# CITY OF ALBUQUERQUE

July 23, 2020

**RE: Albuquerque School of Excellence  
13201 Lomas Blvd. NE  
Revised Grading & Drainage Plan  
Engineer's Stamp Date: 07/20/20  
Hydrology File: J22D050**

RE: **ALBUQUERQUE SCHOOL OF EXCELLENCE  
13201 LOMAS BLVD NE  
REVISED GRADING & DRAINAGE PLAN  
ENGINEER'S STAMP DATE: 07/02/20  
HYDROLOGY FILE: J22D050**

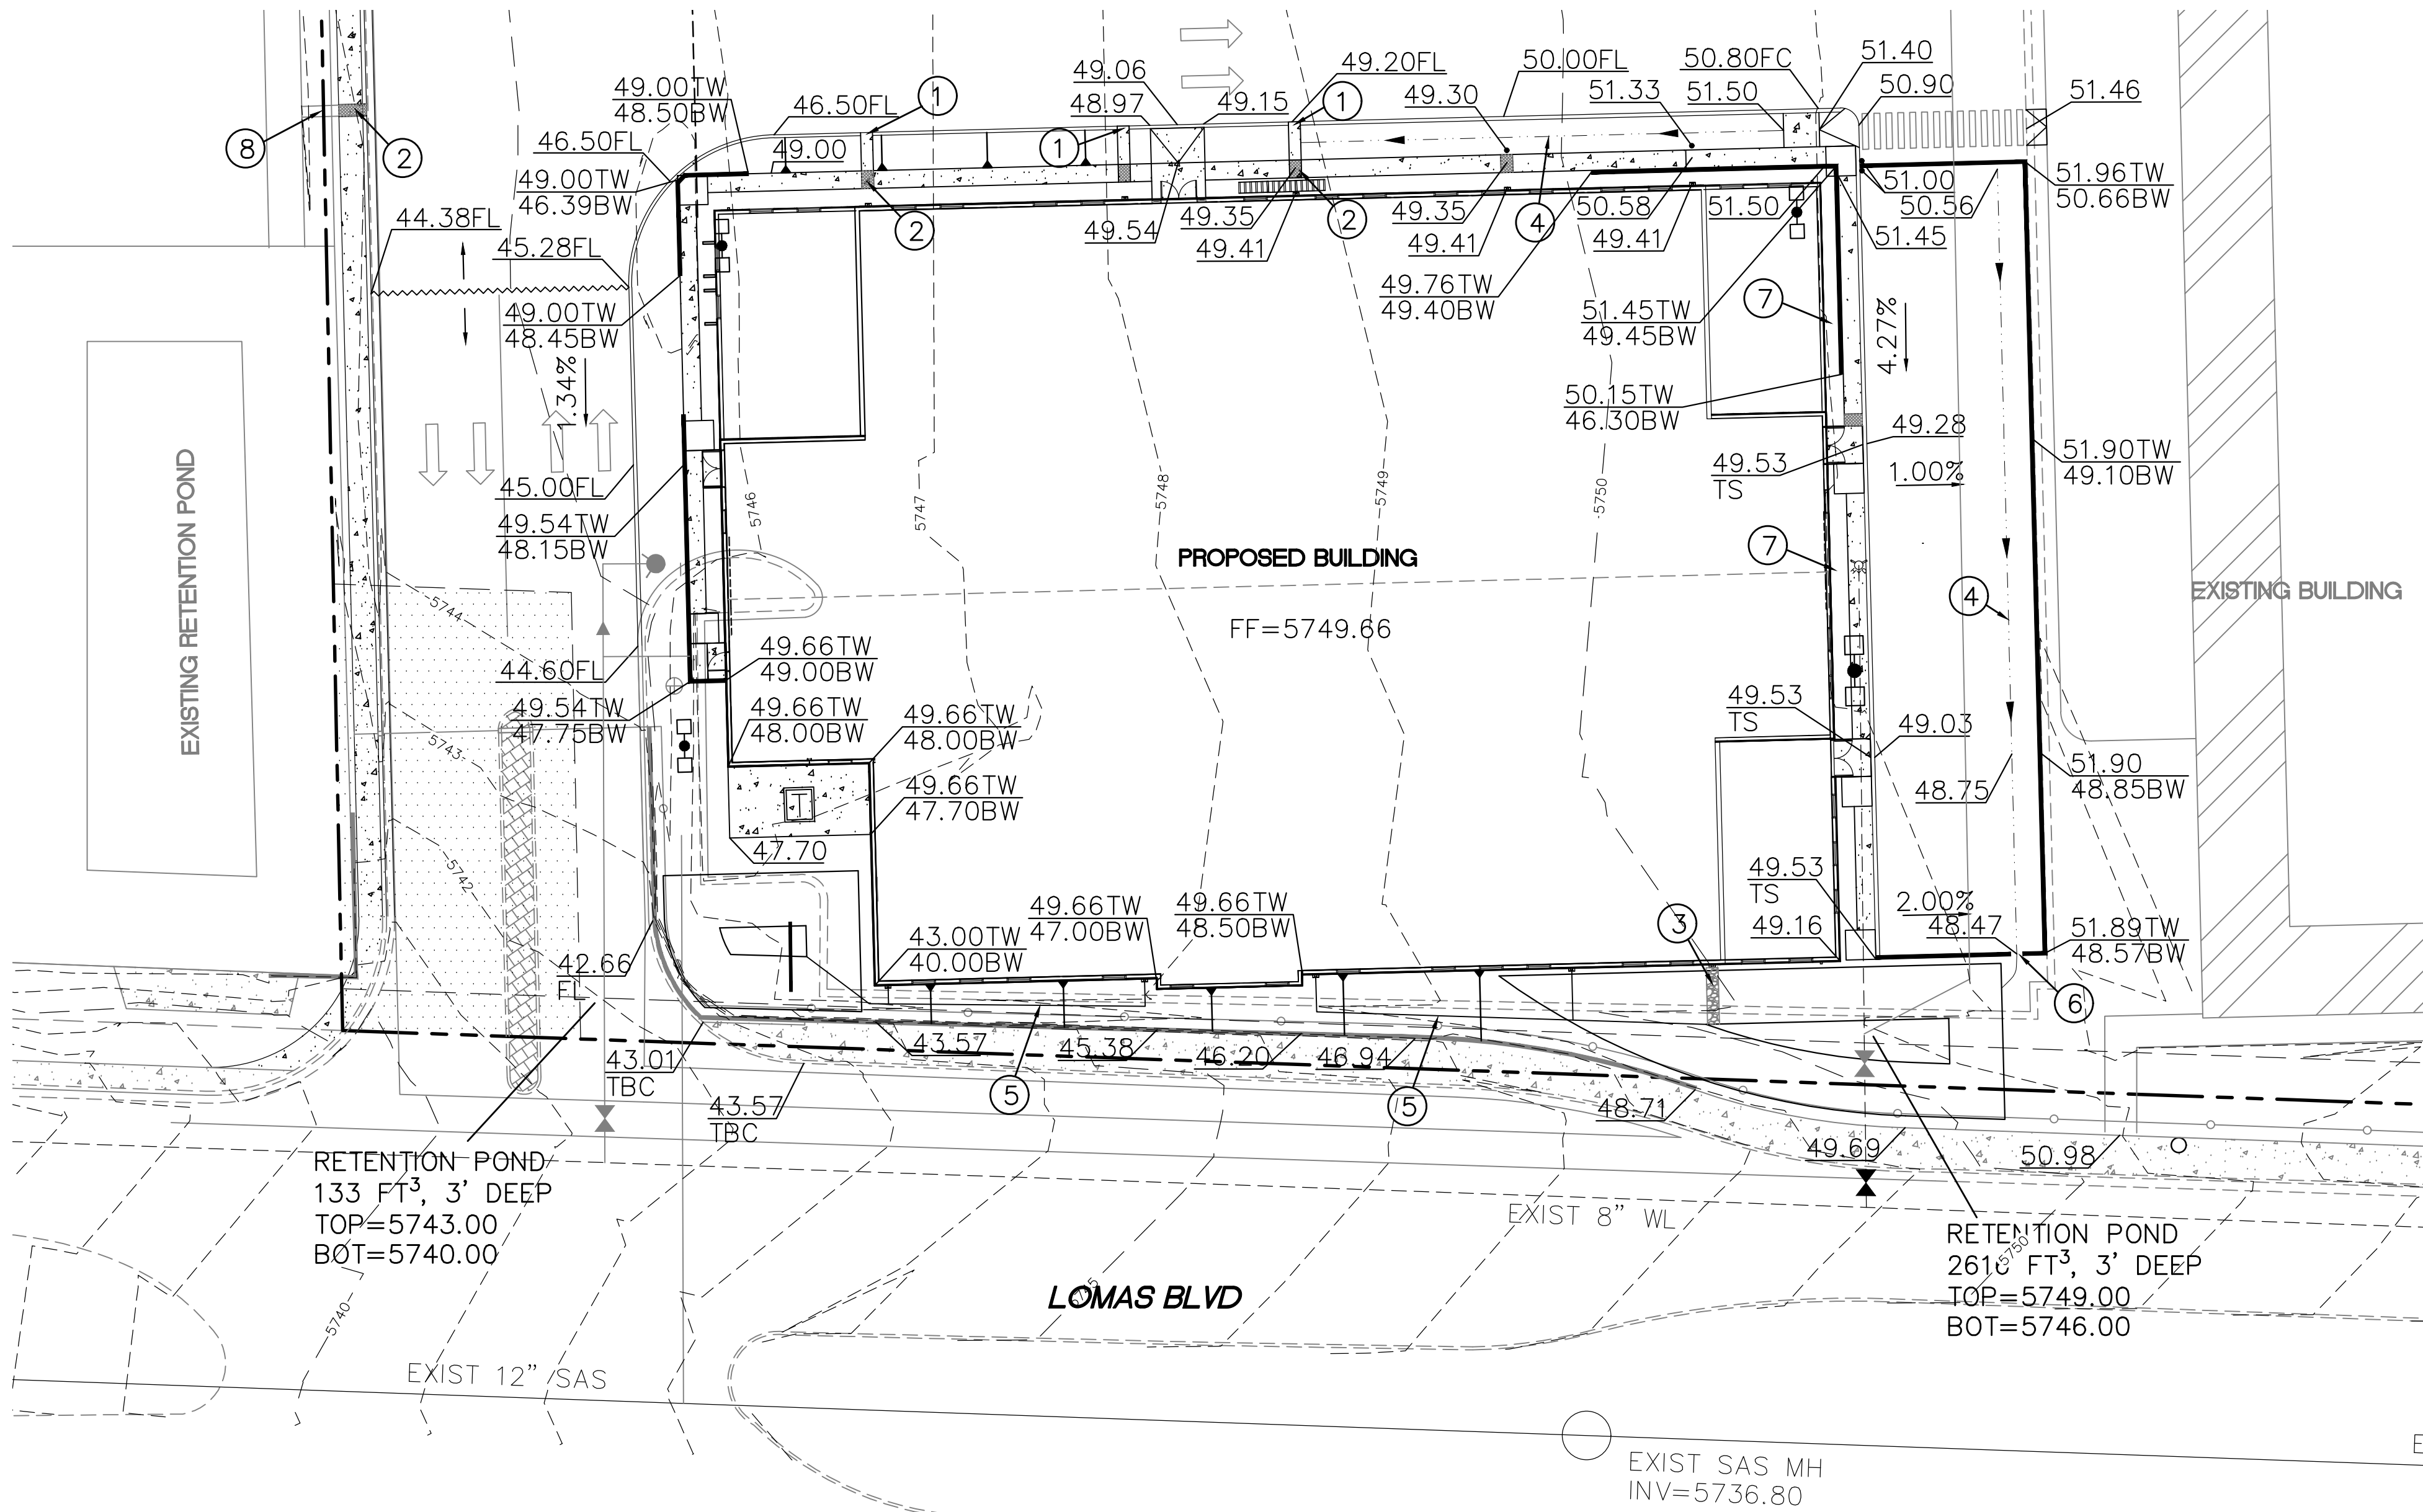
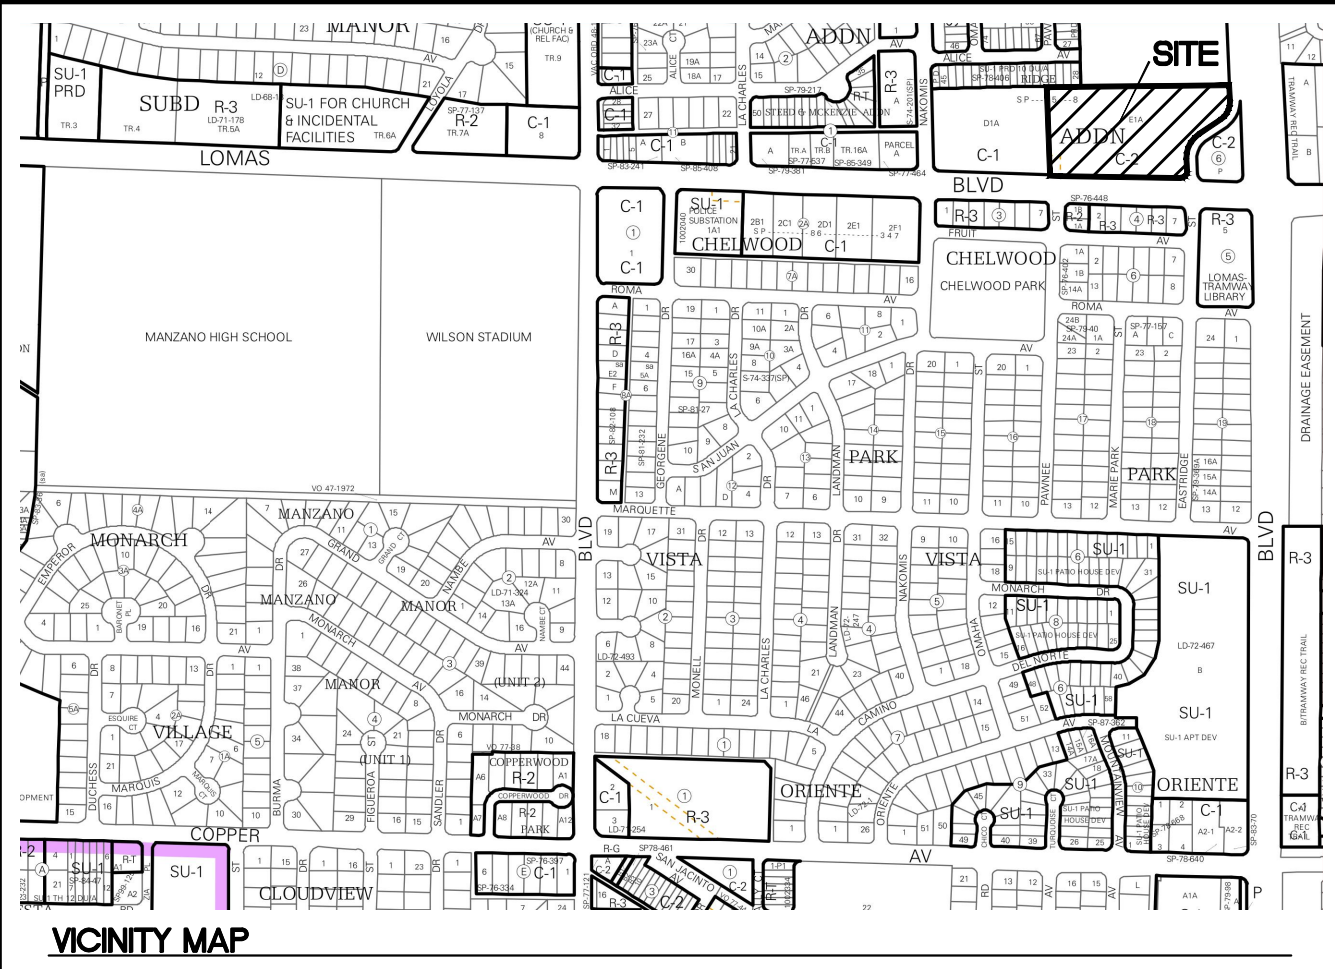
7. Sheet GR-2 sections A-A & C-C please show the emergency spillway (sidewalk culvert) **The emergency spillways were added to the cross-sections.**
8. Sheet GR-2 sections G-G one of the buildings should be labeled as proposed. Please correct. **The building labeling was changed as requested.**

9. Sheet GR-2 the drainage calculations should include the 100 year 6 hour and the 100 year 10 day calculations. The retention pond volumes need to be based on the 100 year 10 day calculations. It is unclear that this was done.  
**The retention pond volumes were changed to allow for the 100 year-10 day volume. Pond "A" will back up into the playground area should that volume be needed. Pond "B" is not big enough to contain the total 10 day volume though it can contain most of it and does contain the 100 year volume. Due to the location of the basin there isn't a large enough area to capture the full 10-day volume. As this is such a small area we believe the intent is met and the small deficient be allowed for this isolated area.**

10. Sheet GR-2 please add the broad crest weir equation (equation 6.60 in the DPM) for the 2 ft. curb cuts and the sidewalk culverts. A coefficient of 2.7 is typically used for the equation  $Q=CLH^{2/3}$ .  
**The weir calculations were added to the plans.**
